Application for a non-material amendment following a grant of planning permission.

Number	
Suffix	
Property name	Land to the south of Ford Lane
Address line 1	east of North End Road
Address line 2	
Address line 3	
Town/city	Yapton
Postcode	BN18 0DS
Description of site location must be completed if postcode is not known:	
Easting (x)	498012
Northing (y)	104001
Description

Reference number:	Y/80/16/OUT & Y/82/20/RES
Date of decision	10/11/2020

Amendment to replace the approved Capital Multi brick to New Cavendish and Thakeham brick to Weston Reds for plots 8-14 & 24-28.

Title:
MATERIALS PLAN

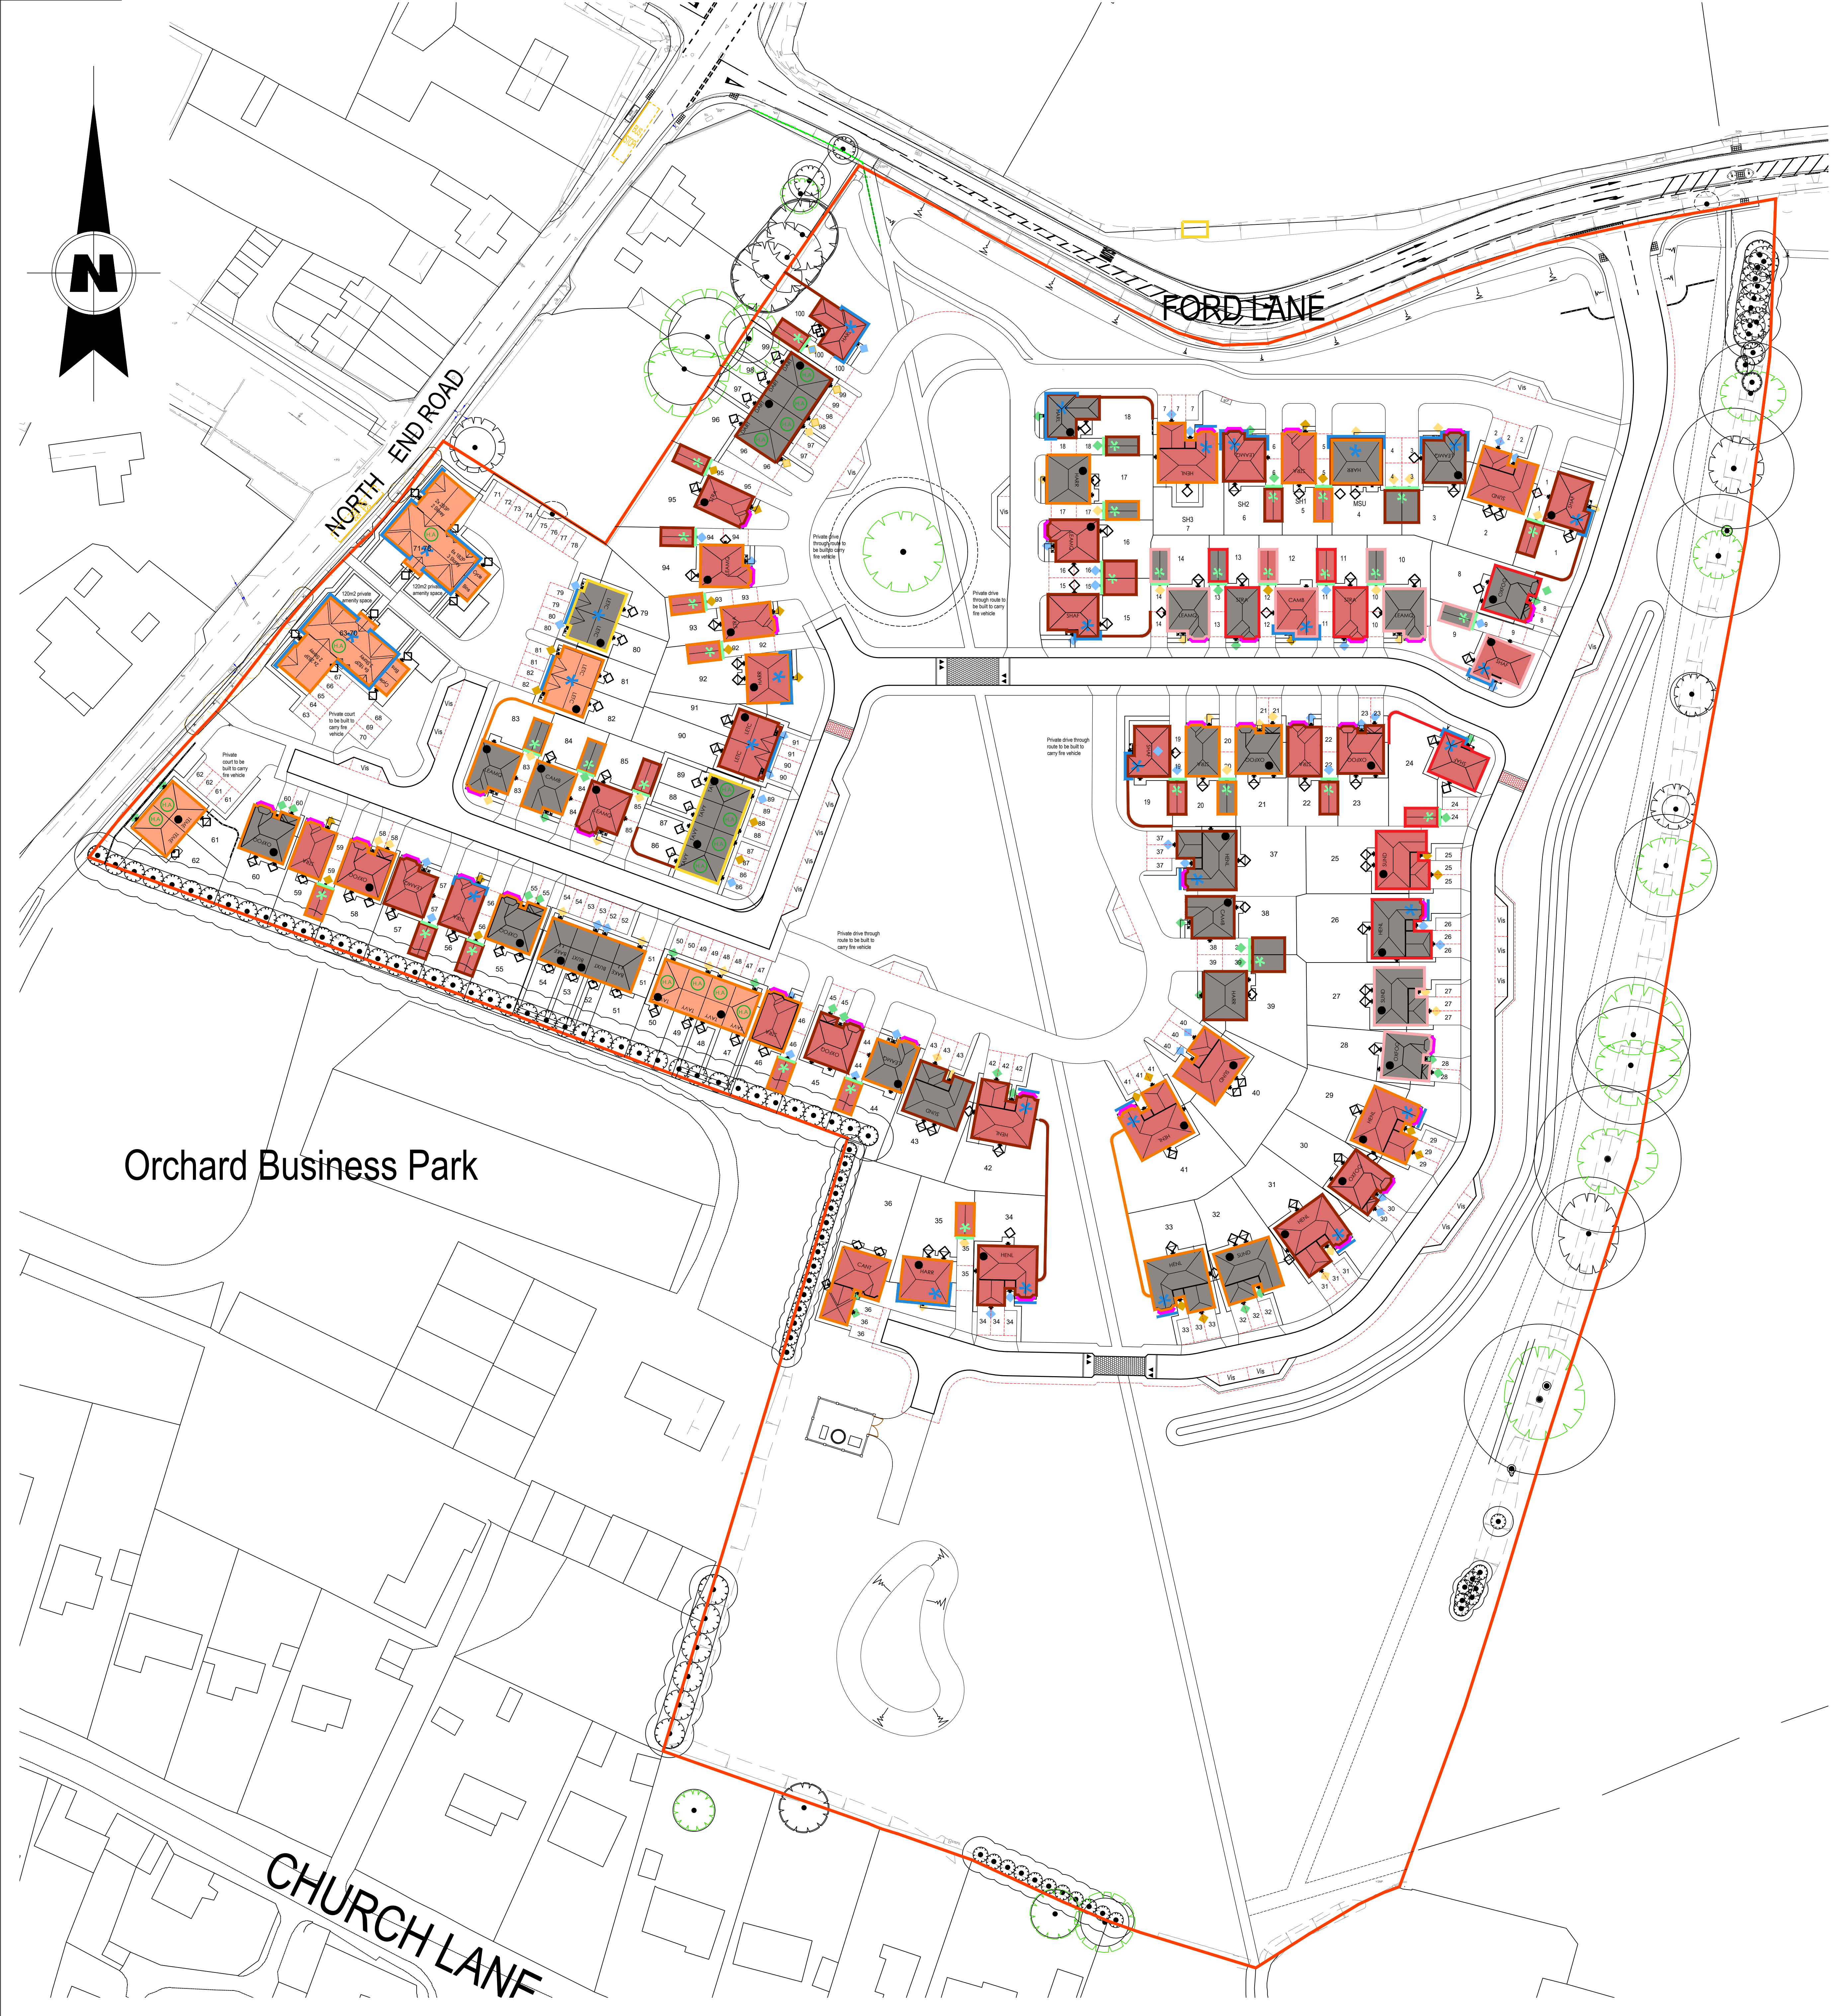
Old plan/drawing numbers
A855 72 Rev B - Materials Plan
New plan/drawing numbers
A855 72 Rev C - Materials Plan
Please state why you wish to make this amendment
Due to issues at the brick manufacturer we have been unable to stock the approved bricks for the whole development. The replacement bricks are very similar

in appearance.
